KIRKLEES METROPOLITAN COUNCIL INVESTMENT & REGENERATION SERVICE

DELEGATED DECISION TO DETERMINE APPLICATIONS FOR LISTED BUILDING CONSENT

Reference No:	2026/65/90428/W
Site Address:	12, Waller Clough, Waller Clough Road, Bolster Moor, Huddersfield, HD7 4NN
Description:	Listed Building Consent for the replacement of existing softwood timber windows with double-glazed aluminium casement windows
Recommending Officer:	Joanna Rednall

Officer Report

05 WINDOW SECTION
002 1:5

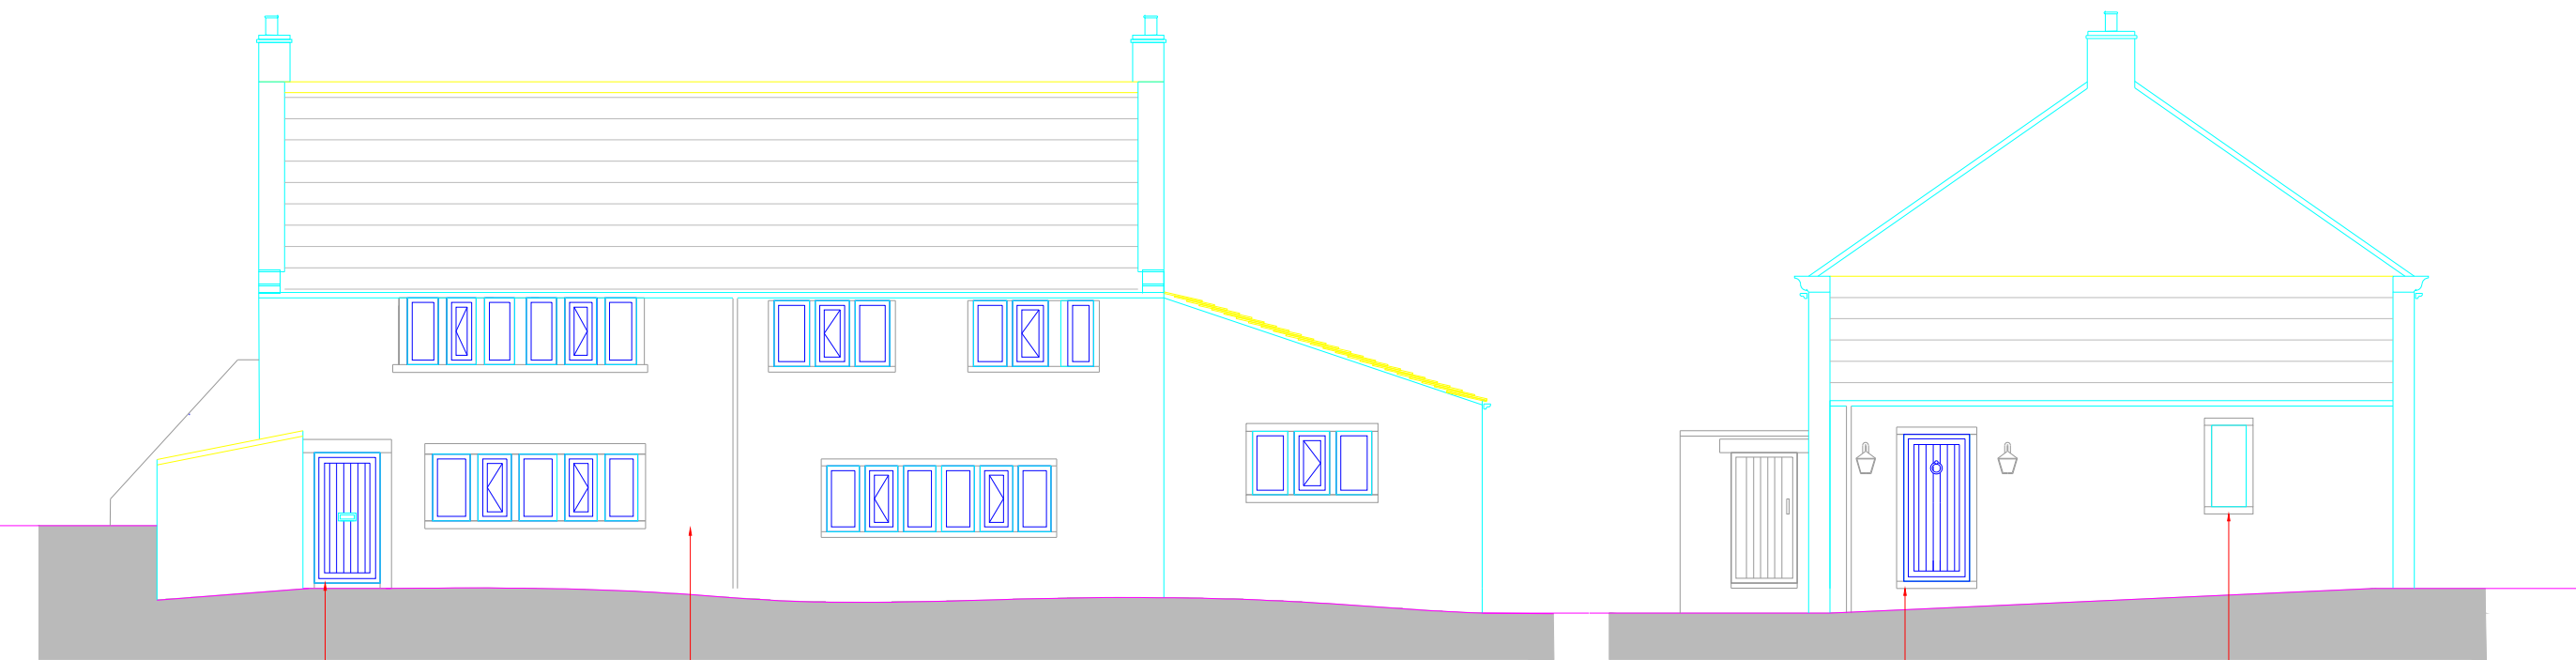
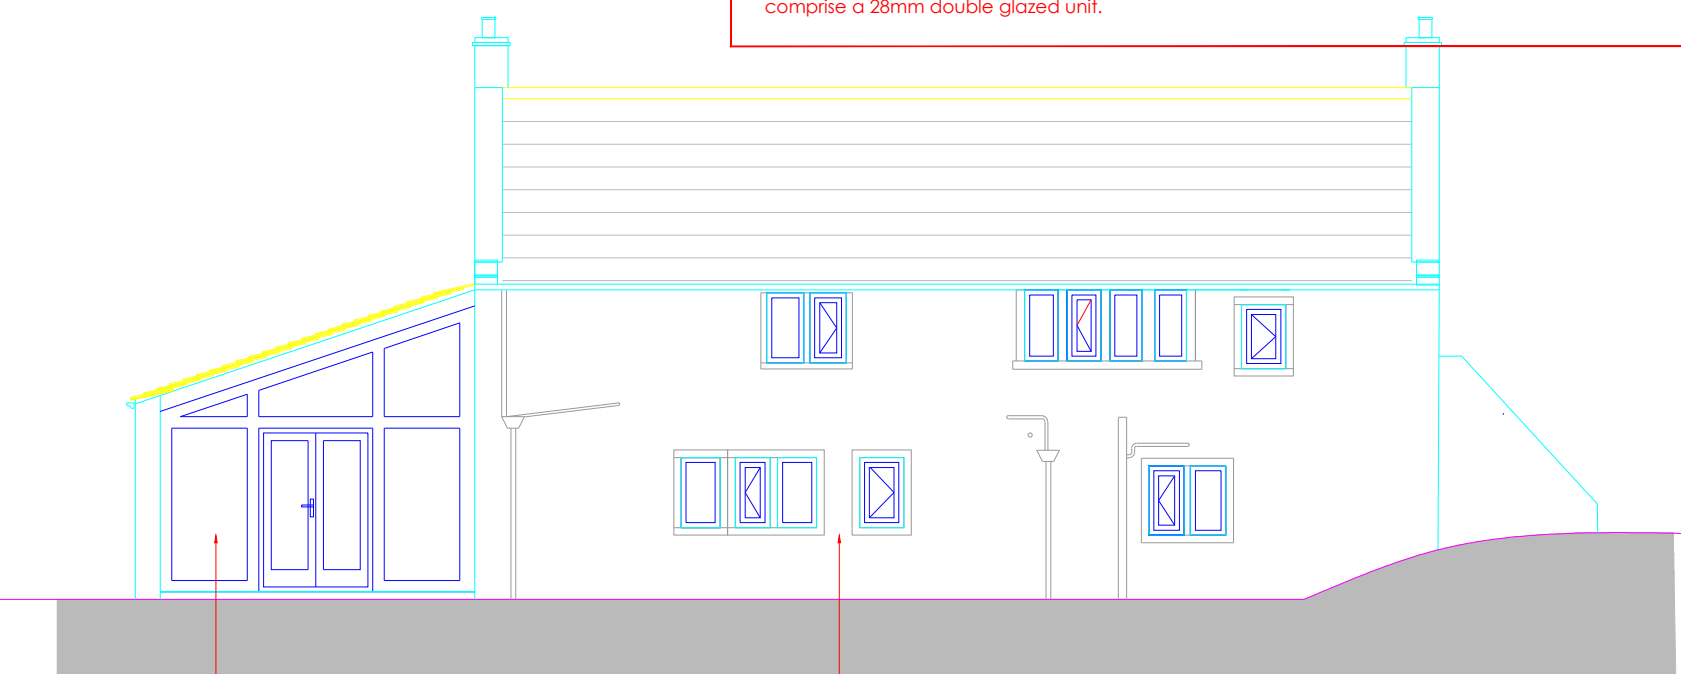
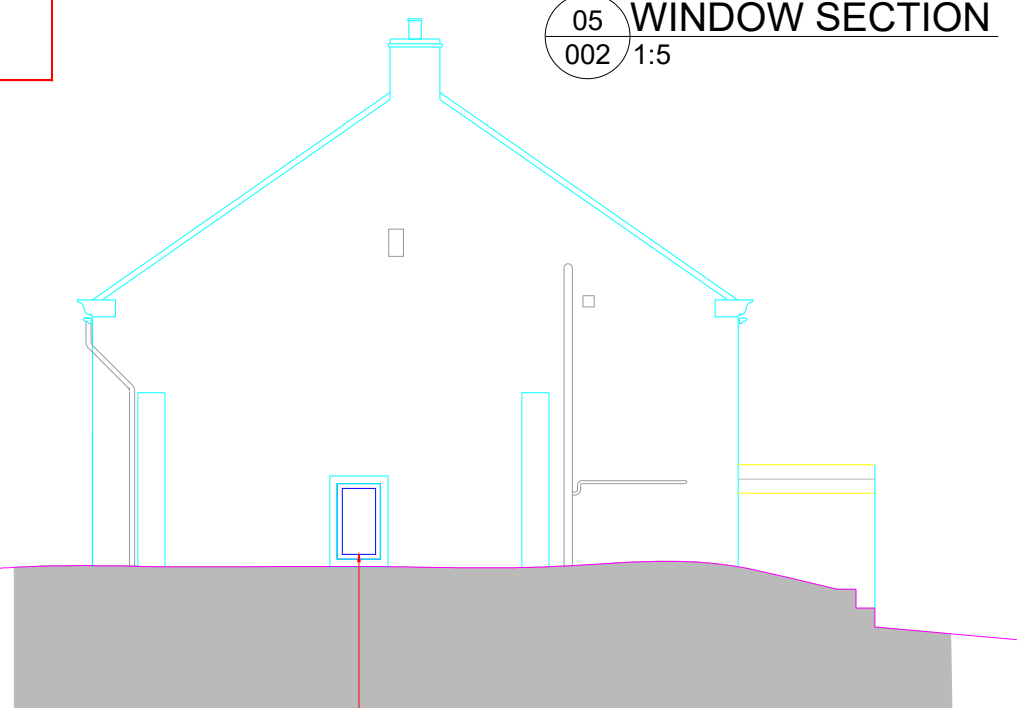
Amended plans were requested to include a 1:5 section drawing, details of the friction hinges, and confirmation of the glazing specification. The submitted plans confirmed that the units are 28mm double-glazed. The agent also confirmed by email that the windows cannot be manufactured with butt hinges, that the existing timber windows do not use butt hinges, and that the units cannot be produced to a 24mm depth as suggested in the Conservation Officer's comments.

The additional information has been reviewed by the Council's Conservation and Design Officer. Officers initially sought the use of butt hinges to better reflect traditional detailing; however, the applicant's agent confirmed and supported by manufacturer information, that butt hinges cannot be used with the proposed system and noted that the existing timber windows do not currently utilise butt hinges. Officers also requested consideration of a thinner frame or section, but the agent confirmed that the manufacturer is unable to produce the units to a reduced profile, including the 24mm glazing depth referenced in earlier conservation comments.

The windows would be finished in RAL 7035 Light Grey and fitted internally with monkey-tail locking ironmongery. The applicant has confirmed that the windows would operate on friction hinges, which would not be visible externally. The windows would be recessed to a depth broadly consistent with the existing arrangement, between 80mm and 100mm. The glazing would comprise a 28mm double-glazed unit, as confirmed on the amended plans.

3. All new windows shall be side hung casements recessed by 75-150mm and not fitted flush with the external wall. Visible trickle vents shall not be permitted. The windows shall be of a light grey colour finish.
